SITE DEVELOPMENT PLAN
MONUMENT STEEL STRUCTURES
 BUILDING ELEVATIONS AND FLOOR PLANS
 18910 BASE CAMP ROAD
 MONUMENT, COLORADO

Floor Plans_v1-redline.pdf Markup Summary

SHEET NUMBER
BD 1
 6 OF 9

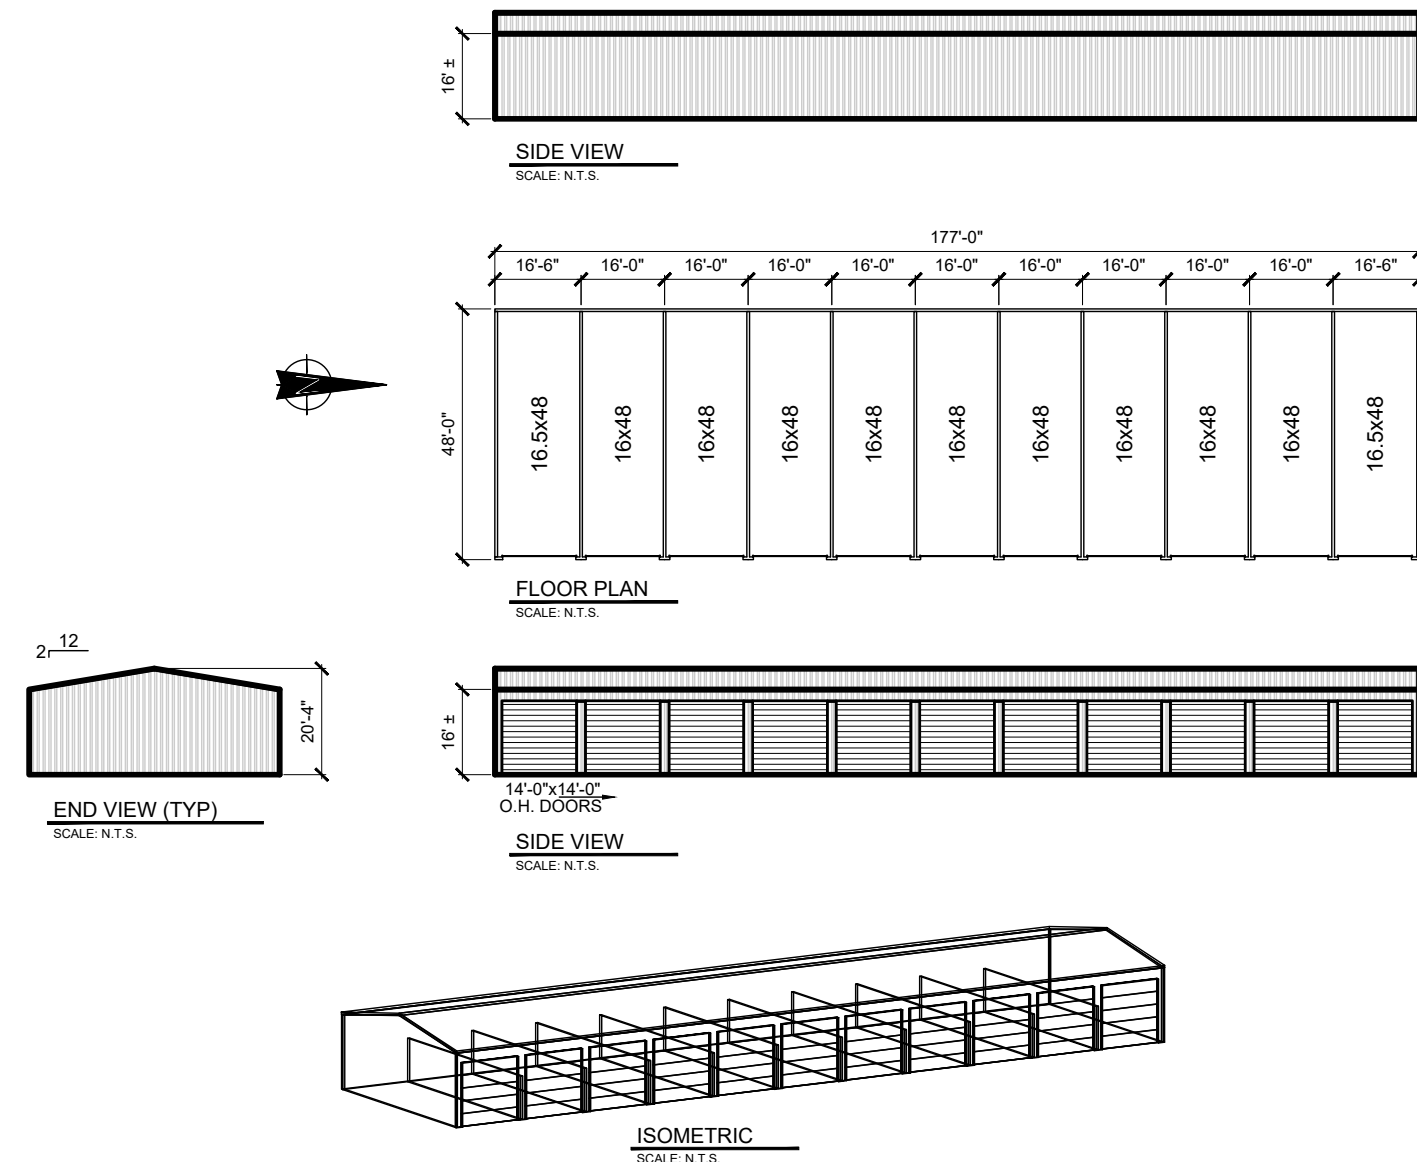
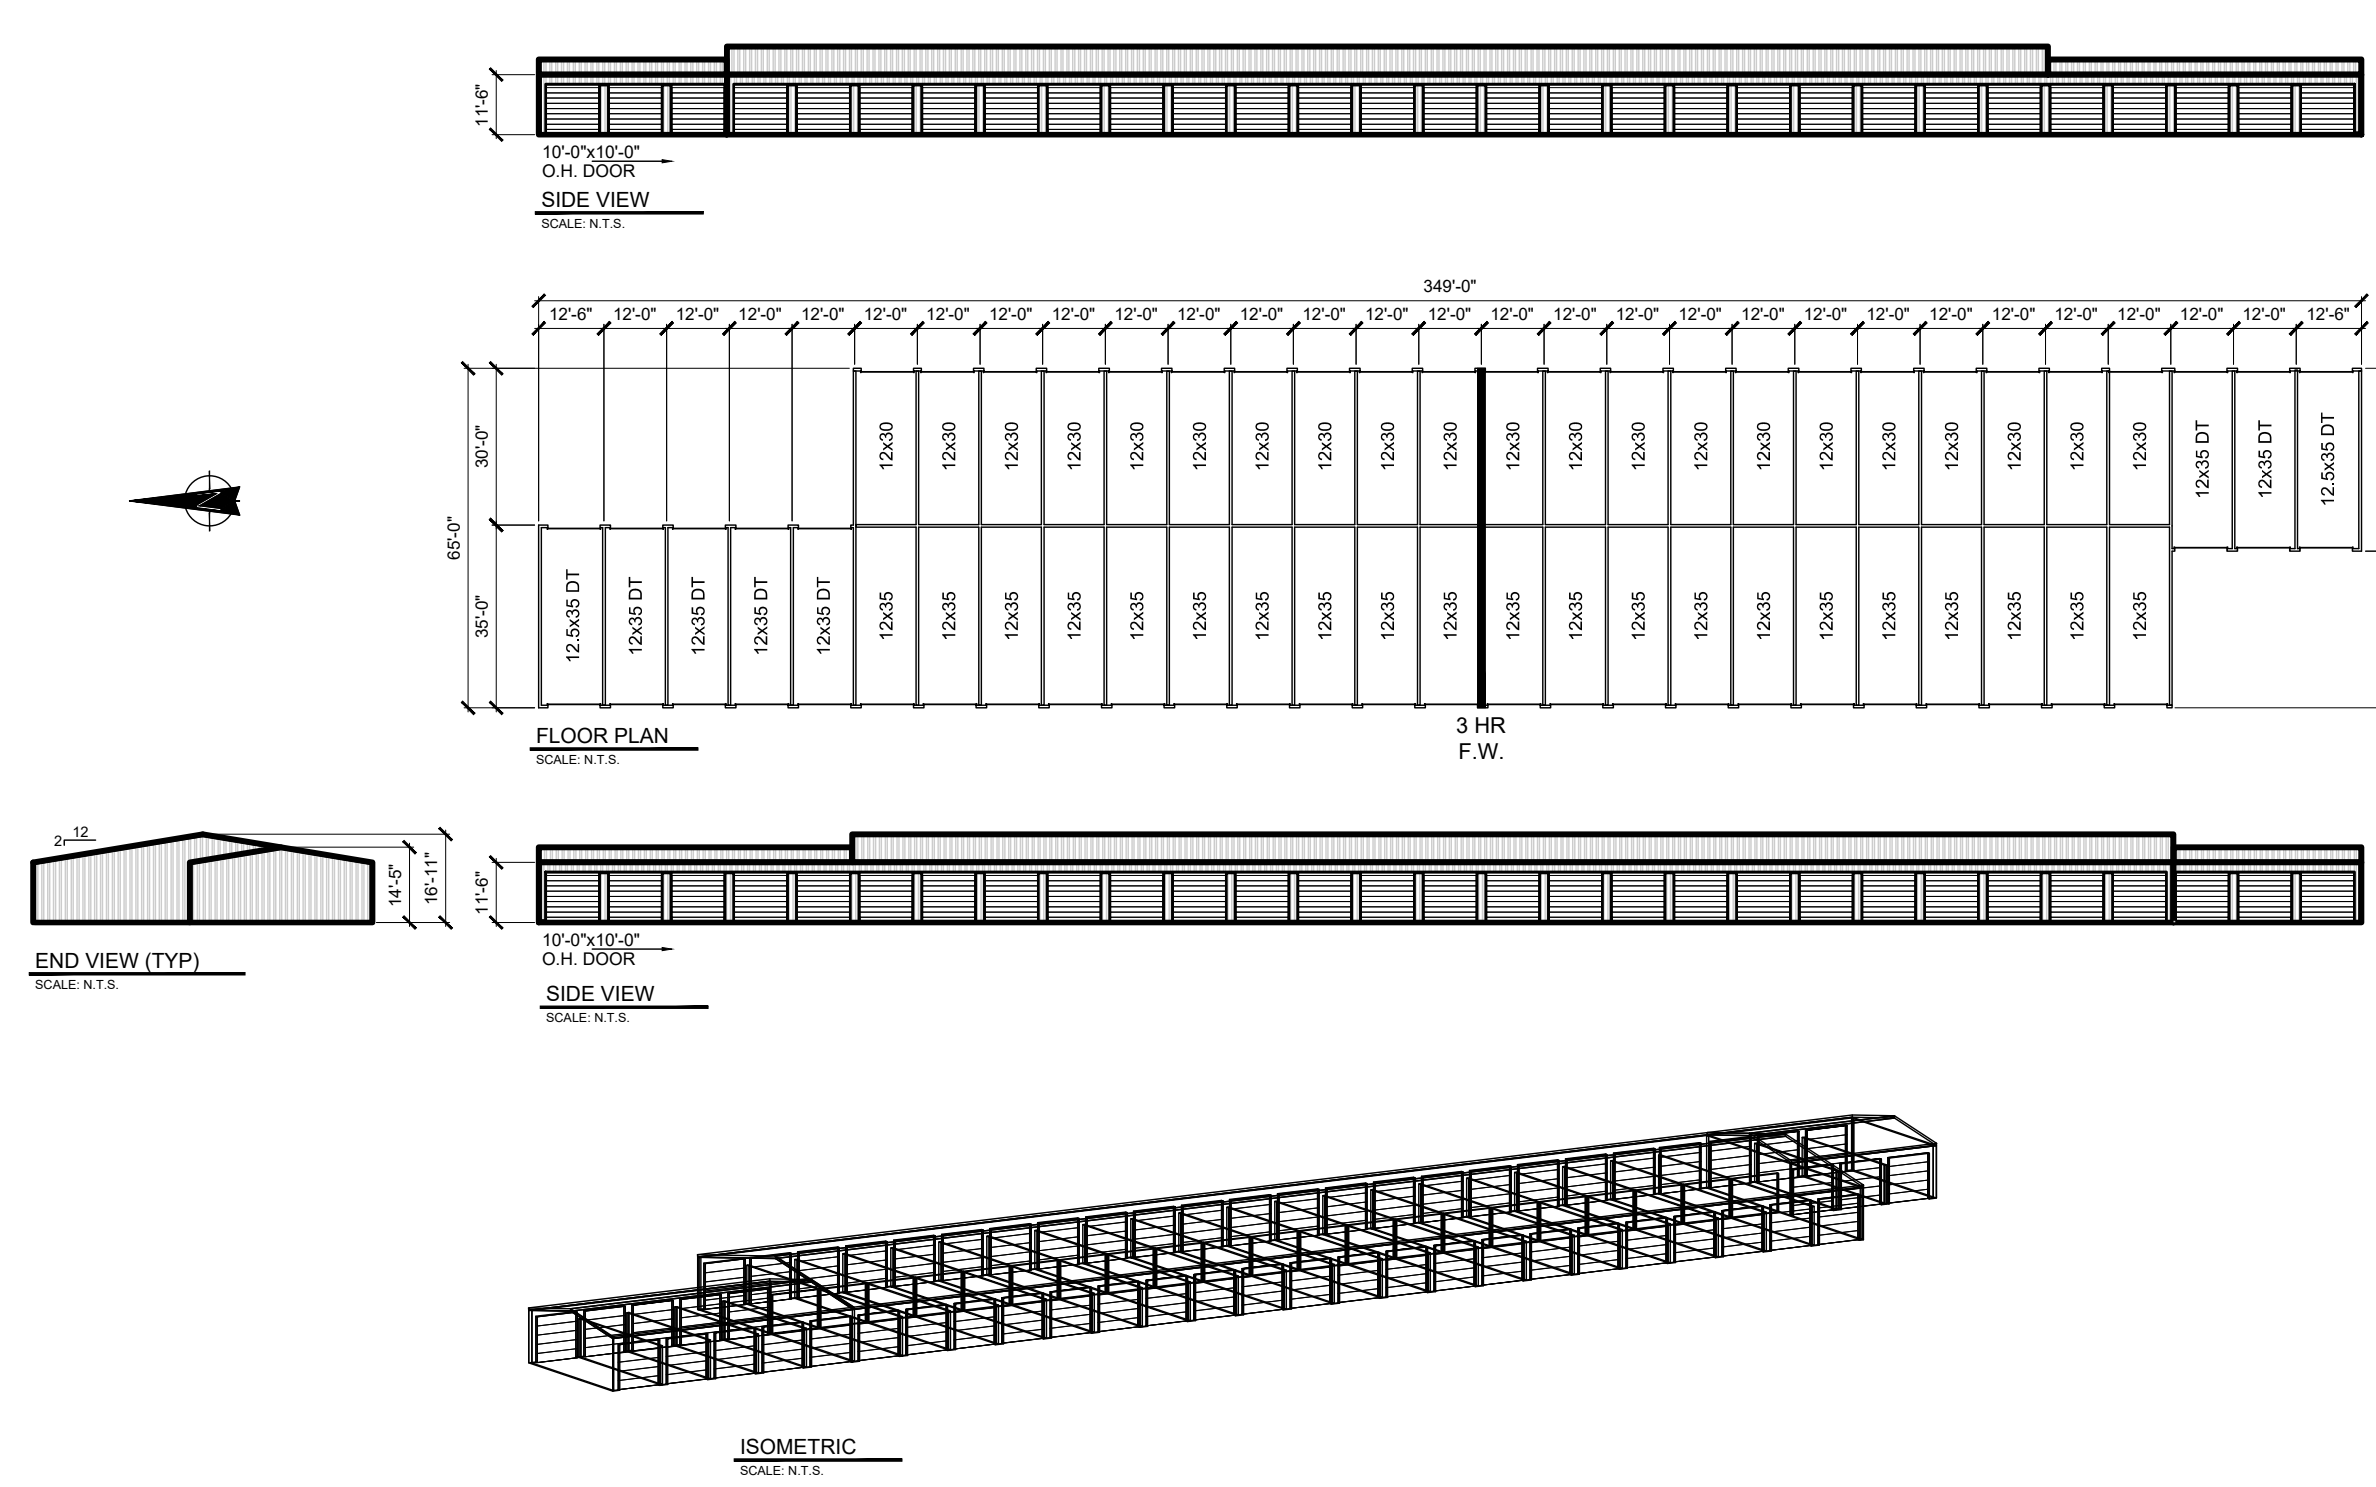
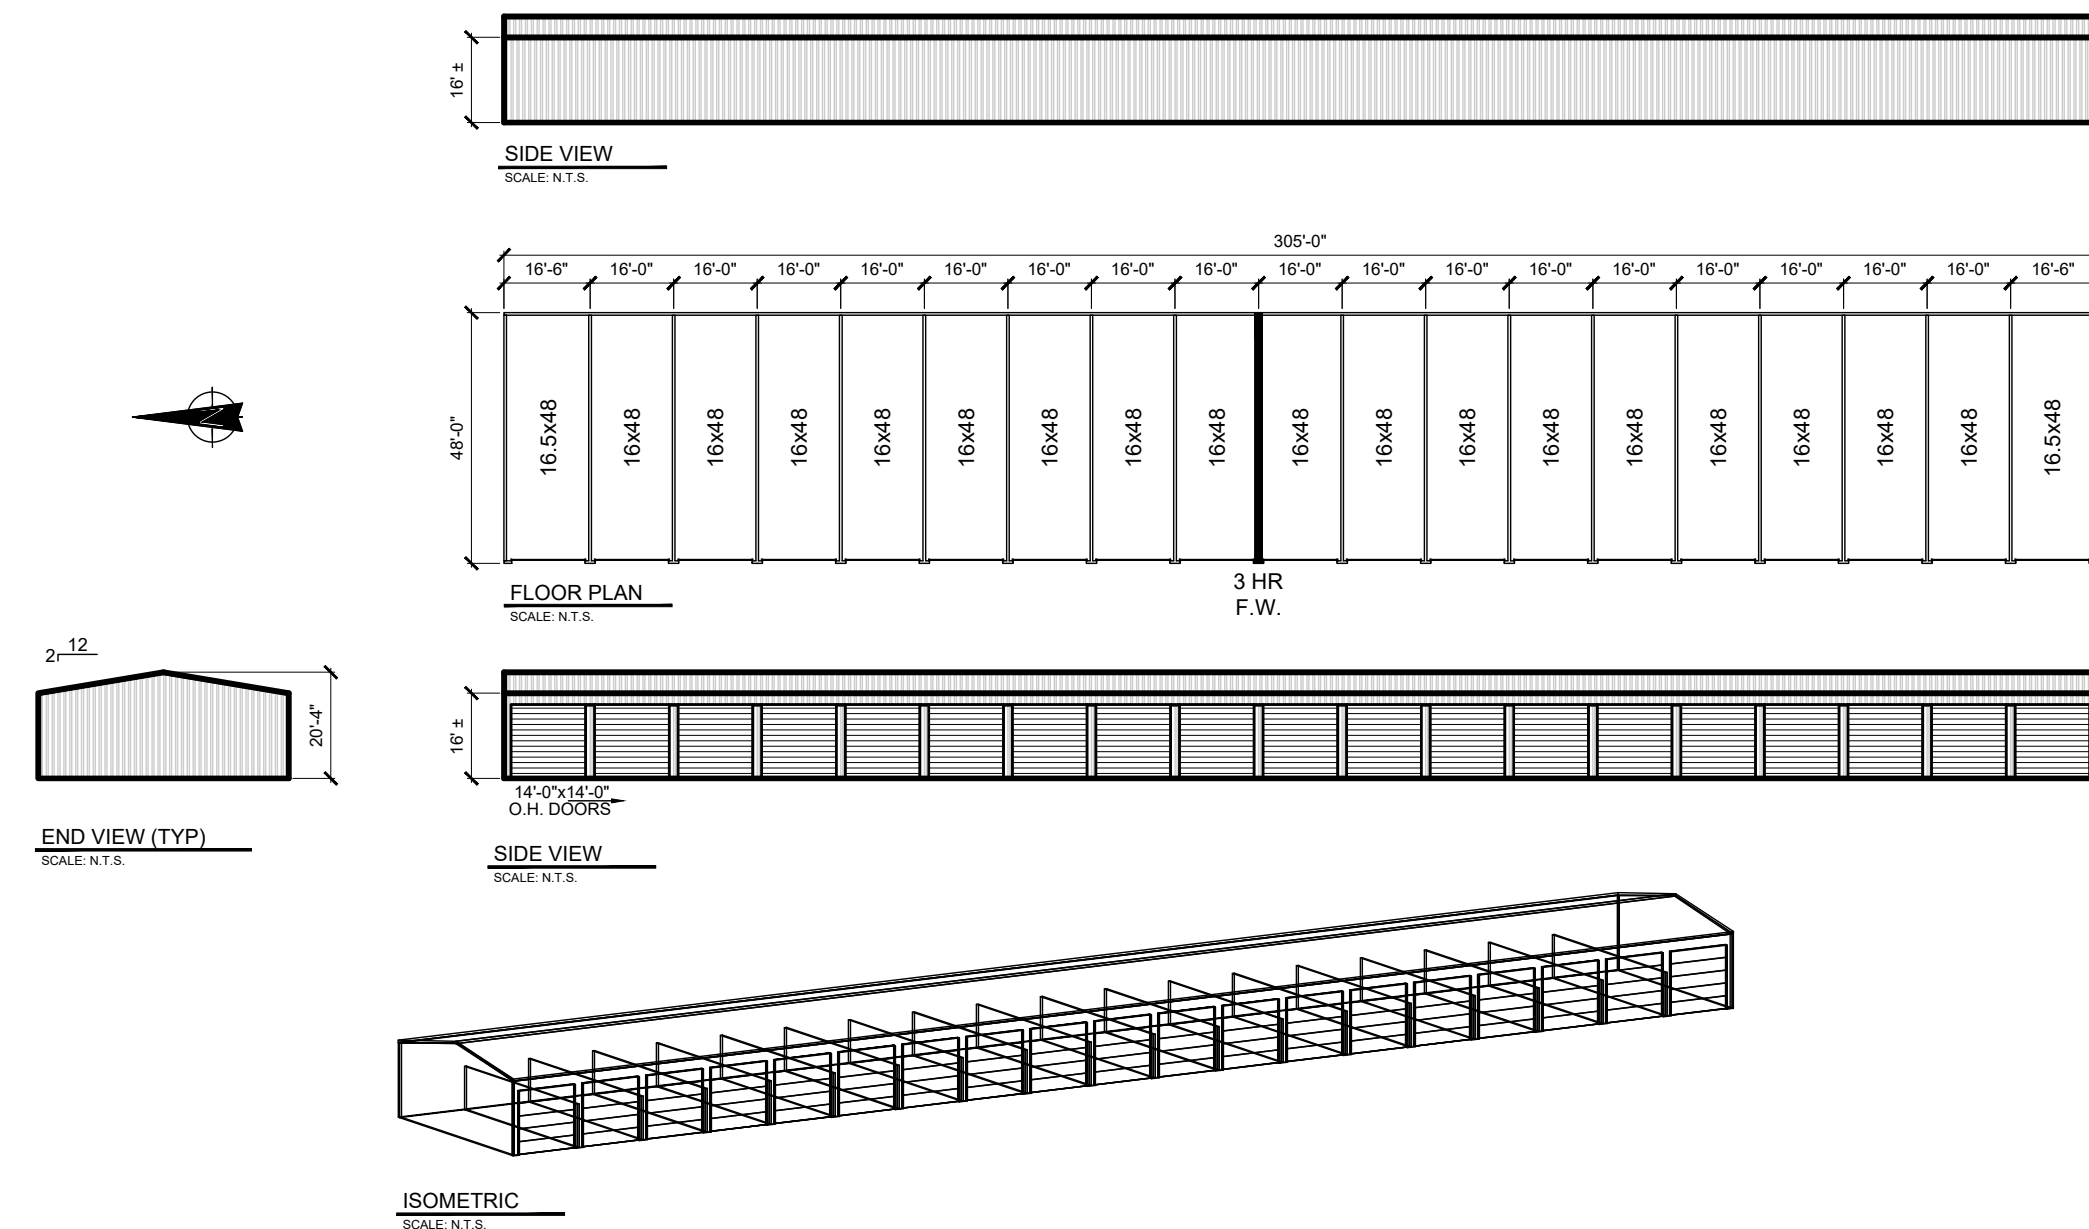
Floor plans not shown. Include dimensions
